Appeal Decision

Appeal Ref: APP/R5510/D/15/3004965

72 Windsor Avenue, Uxbridge, Middlesex UB10 9AY

- The appeal is made under section 78 of the Town and Country Planning Act 1990 against a refusal to grant planning permission.
 - The appeal is made by Mr Manji Brar against the decision of the Council of the London Borough of Hillingdon.
 - The application Ref: 27737/APP/2014/3643, dated 3 October 2014, was refused by notice dated 4 December 2014.
 - The development proposed is the demolition of existing store and addition of a single storey side extension.
-

DRAWING TITLE:
EXISTING ELEVATIONS

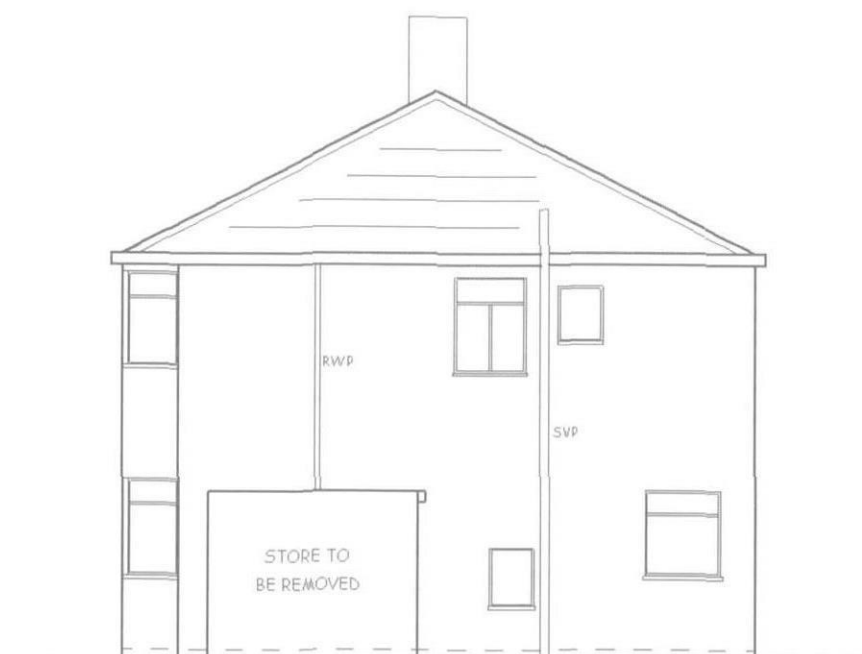
6. The existing store breaches the return building line and is wider than the existing dwelling and as such is contrary to the HDAS. However, its step back from the front elevation, limited depth, flat roof form and lack of fenestration on the front and side elevations make it a subordinate structure within the street scene. The front elevation appears as a boundary wall, with additions above the brickwork, which separates the front garden from the rear garden.

PROPOSED GROUND FLOOR

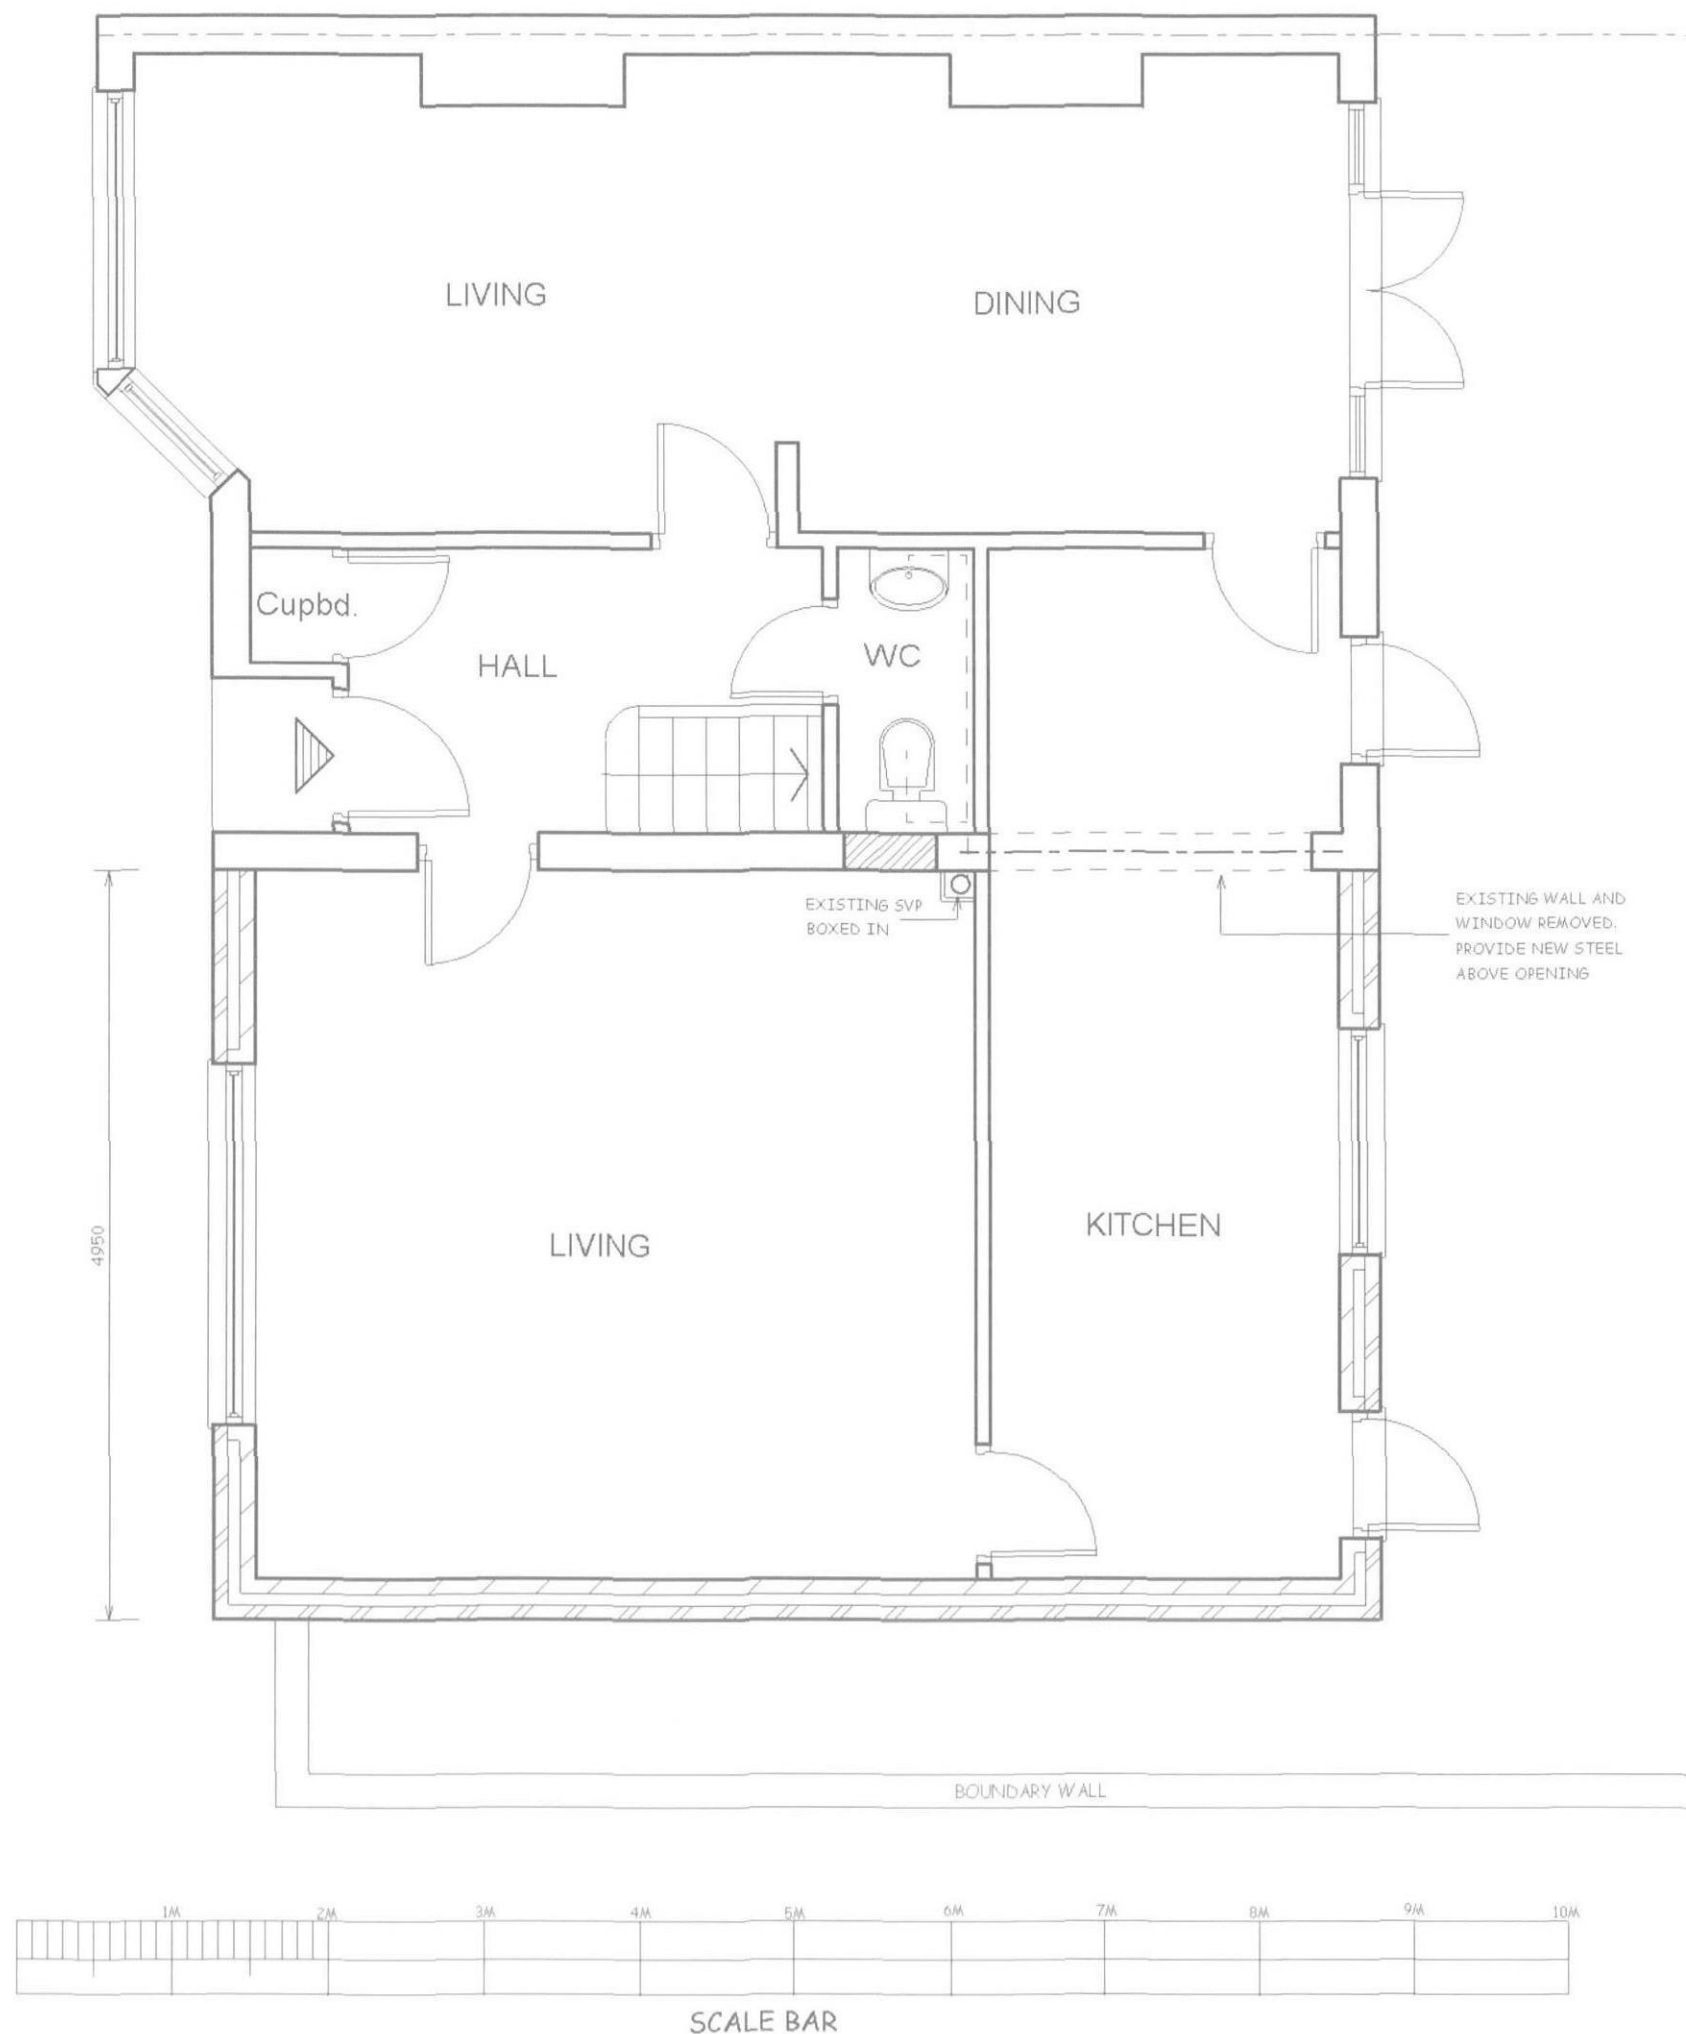
7. The appeal property sits on a large corner plot. The proposed extension would not be as wide as the existing store structure and would introduce a gap of about a metre between the flank elevation and the boundary with Ryefield Avenue. I consider this is an improvement over the existing relationship of the store structure with the boundary. Adequate room exists within the plot to accommodate the proposed extension and it would not appear as either cramped or overdeveloped.

PROPOSED ELEVATIONS

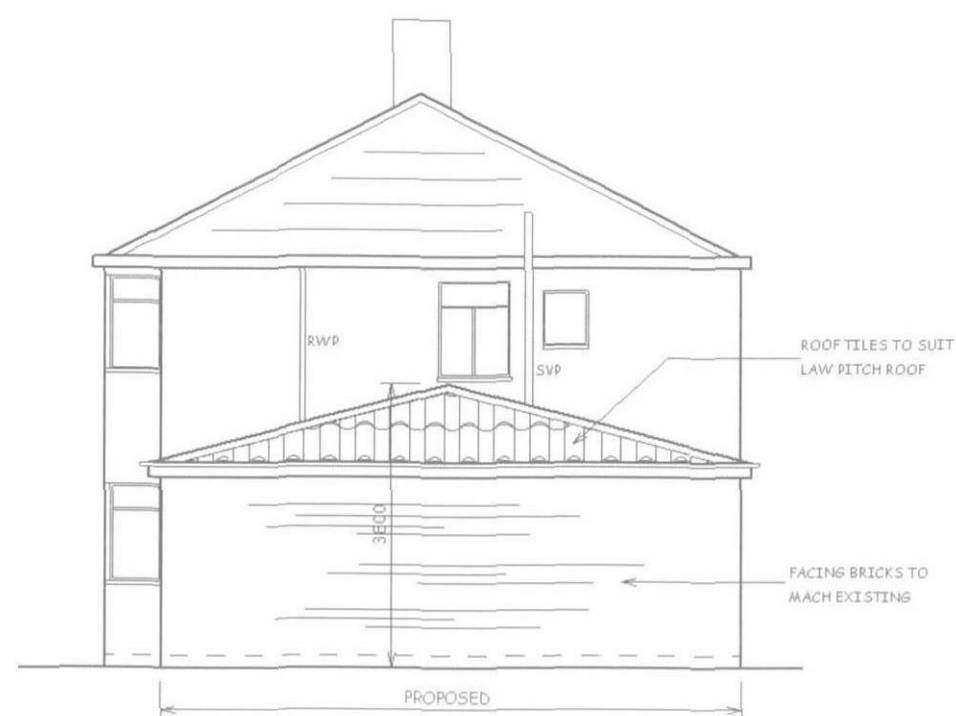
4. The proposed single storey extension would be about 5.95m wide, extending to about 1m from the side boundary with Ryefield Avenue. Its front elevation would be in alignment with the existing front elevation of No 72 and be the same depth as the host dwelling. It would have a hipped roof with tiles to suit the low pitch of the roof. There would be a four pane window to the front elevation and a door and window on the rear elevation.

8. However, the proposed extension would have a greater height and depth and be significantly bulkier than the existing store structure. The roof form would increase the bulk of the structure compared with the existing flat roofed store structure. Furthermore, the proposed roof of the extension would fail to harmonise with the pitch or form of the host property. The low pitch of the proposed roof would appear incongruous within the street scene and it would be contrary to guidance within the HDAS. Due to the large bulk and prominence of the proposed roof this adds significantly to my concerns.

9. In addition no details of what type of roof tile would be capable of being used on such a low pitched roof or whether the roof tile/material would complement the existing roof materials of the host property. This concern could not be overcome by the imposition of a condition requiring approval of materials as the pitch may not accommodate appropriate tiles. The appellant has also indicated that he would be willing to amend the height of the roof/introduce a crown roof to the structure. No details of a revised scheme are before me. In any event it would represent a material change to the proposed scheme which must be put to the Council in the first instance to ensure that not other interests would be prejudiced. Such changes cannot be accepted as part of this appeal.

12. The proposed extension, due to its overall bulk, incongruous roof and prominence within the street scene would harm the existing character and appearance of the immediate area and the host property. This would be contrary to saved Policies BE13, BE15 and BE19 of the London Borough of Hillingdon Unitary Development Plan (adopted 1998) which require development to harmonise with the scale, form, architectural composition and proportions of the original building and the existing street scene and complement or improve the amenity and character of the area. It would also be contrary to Policy BE1 of the Hillingdon Local Plan Part 1 Strategic Policies (Adopted November 2012) which requires development to achieve a high quality of design which enhances the local distinctiveness of the area, and to contribute to community cohesion and a sense of place.
